From: [Aaron Mostofi](#)
To: [Dusty Pilkington](#)
Subject: RE: VA-16-00001 Mostofi
Date: Wednesday, September 28, 2016 2:10:27 PM

RE: VA-16-00001 Mostofi

After review of the variance application, I have the following comments:

VA-16-00001

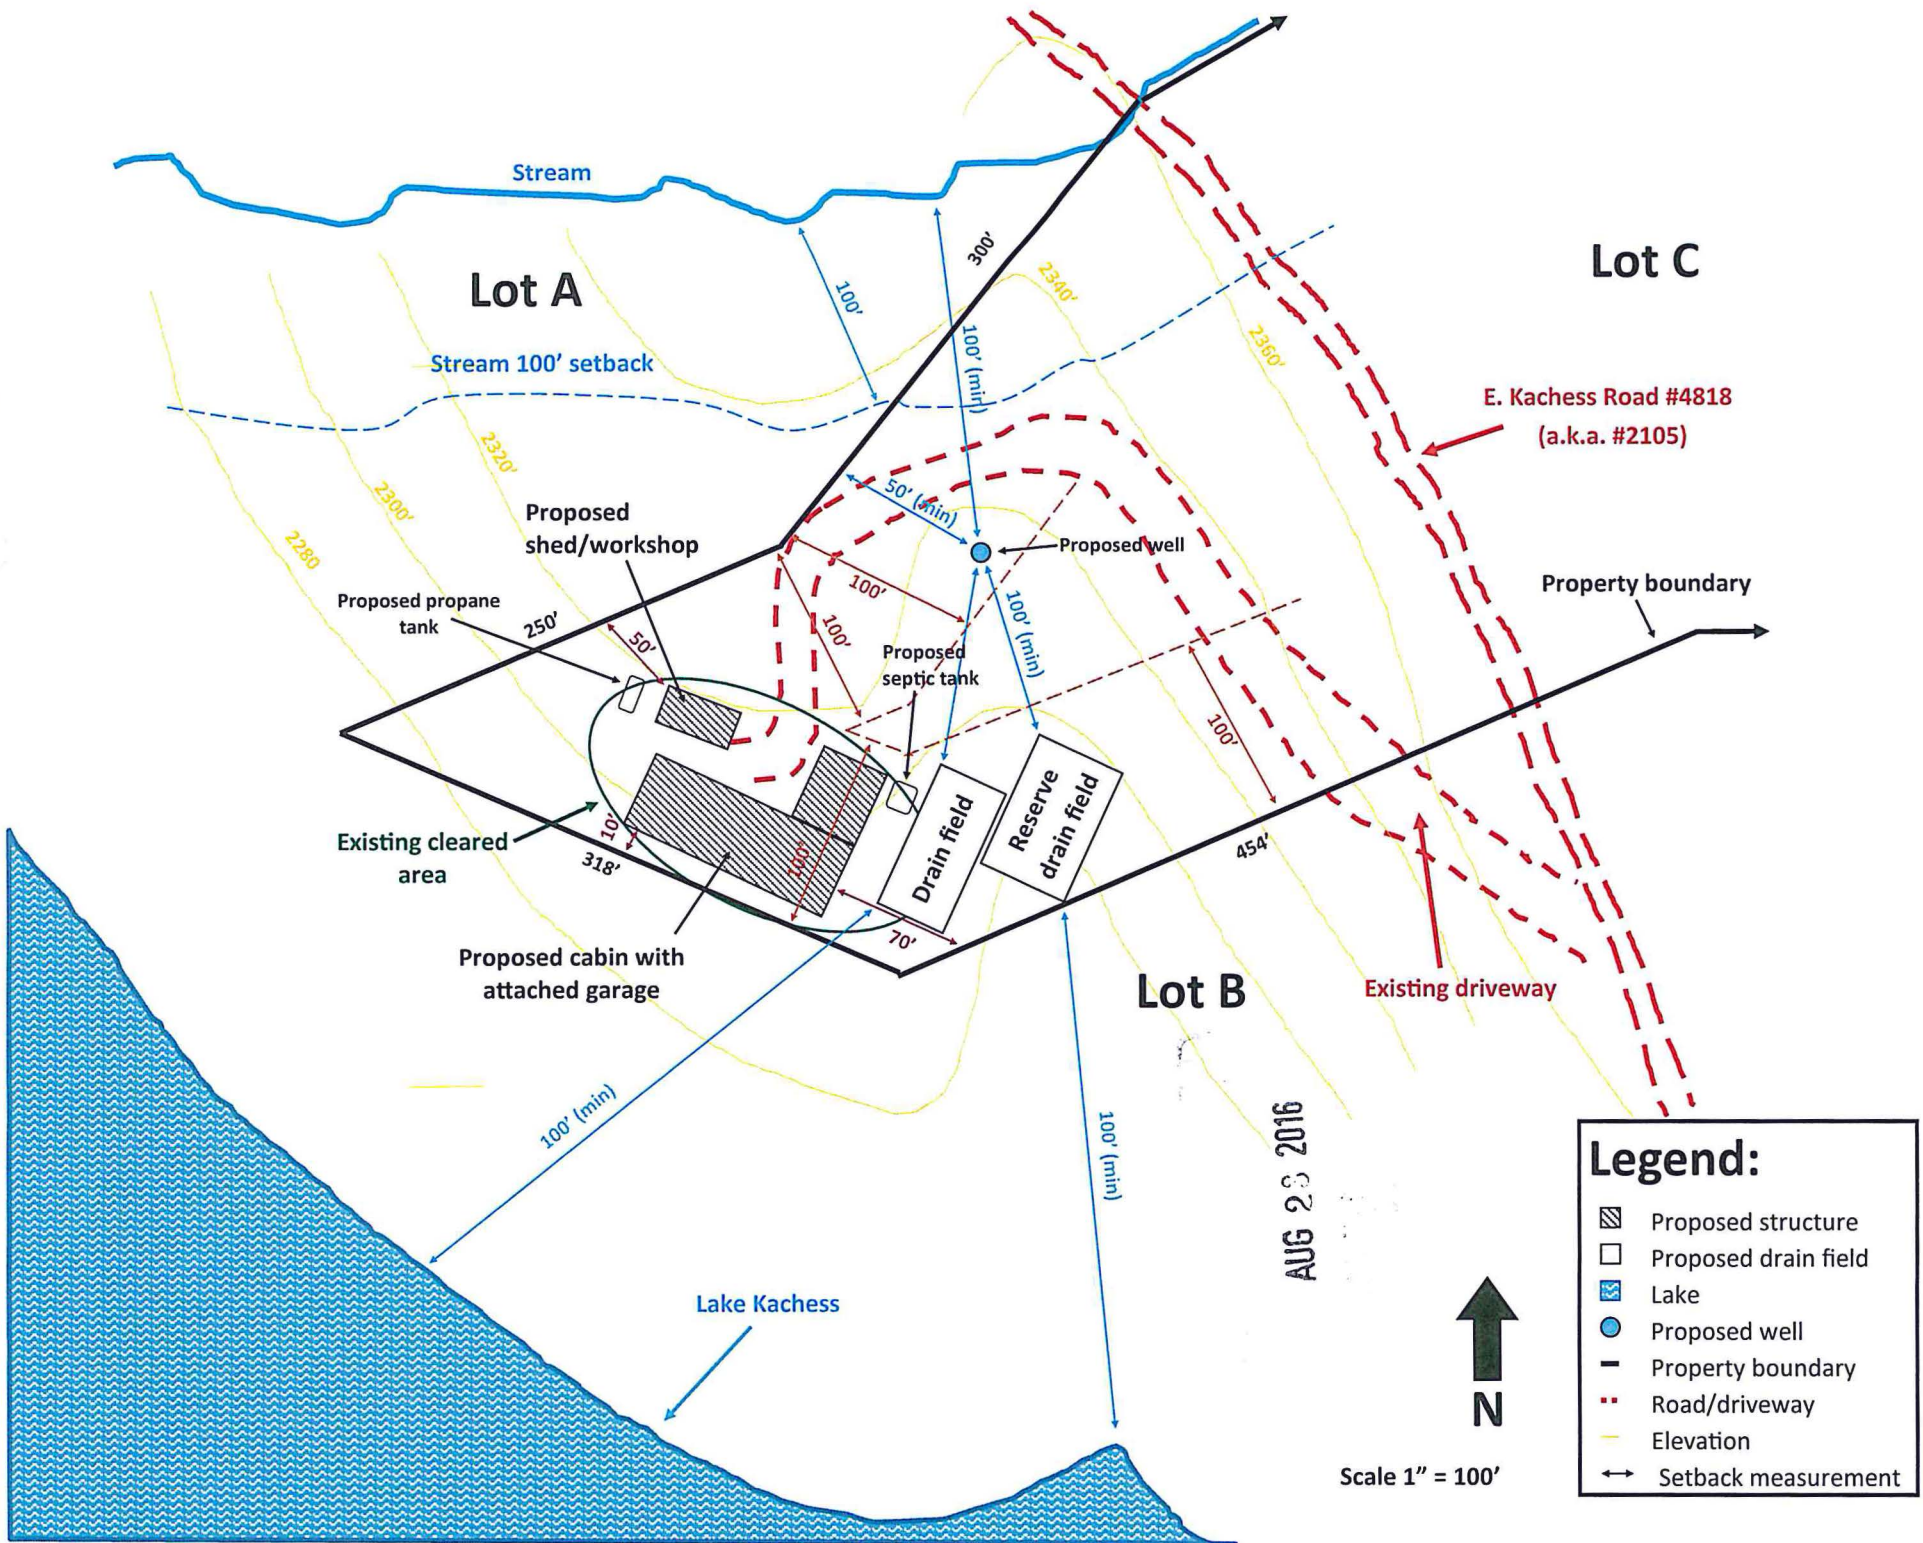
1. The CDS Building Division has no objection for the applicant to encroach into the setback. Distance to be determined by Planning Division.
2. Due to steep slopes on the property, full geo-tech and soils report is required as well as engineered building plans.
